**App no: 24.0998**

**Address: The Compleat Food Group Lincoln Way Clitheroe BB7 1QL**

**Proposal: Proposed alterations to car parking, access and installation of new exit gates.**

Site Location Plan

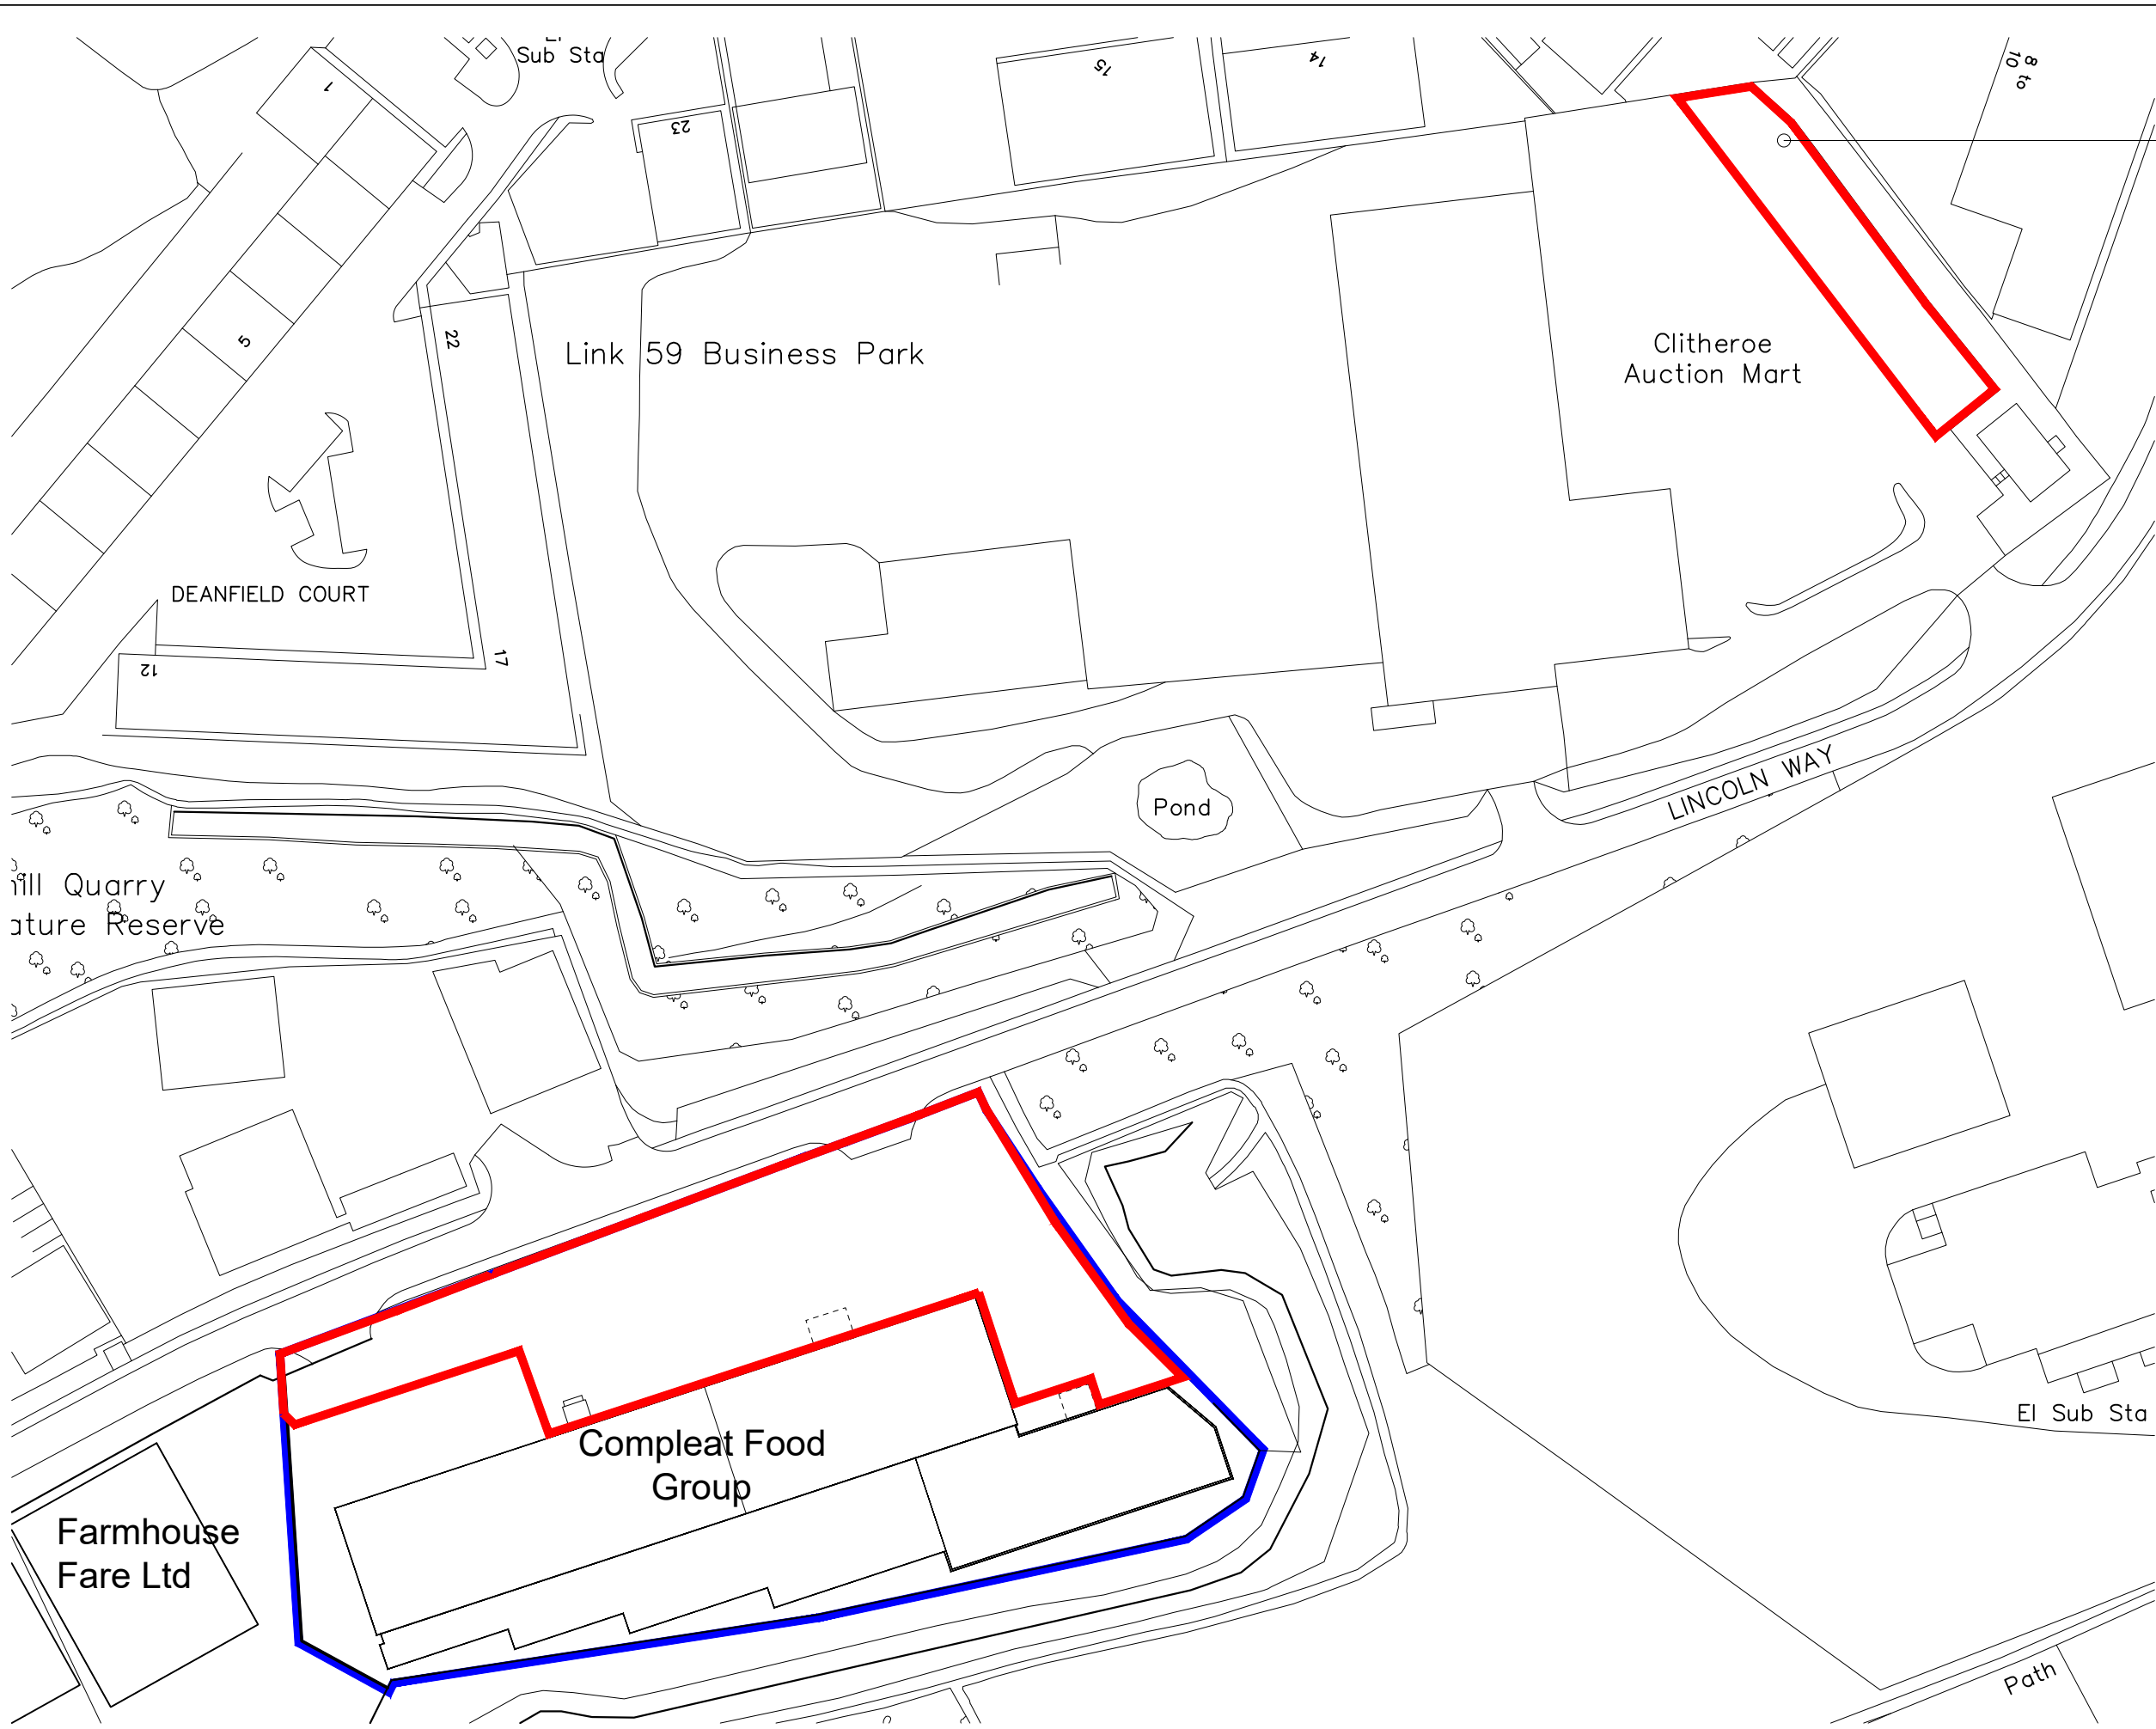
We would request a drawing to show the location of the car parking and confirmation that it is available at all times when staff are on-site and that it does not conflict with any users at the Auction. We would request that if the agreement with the Auction is terminated at any point in the future, that a replacement car parking provision is provided.
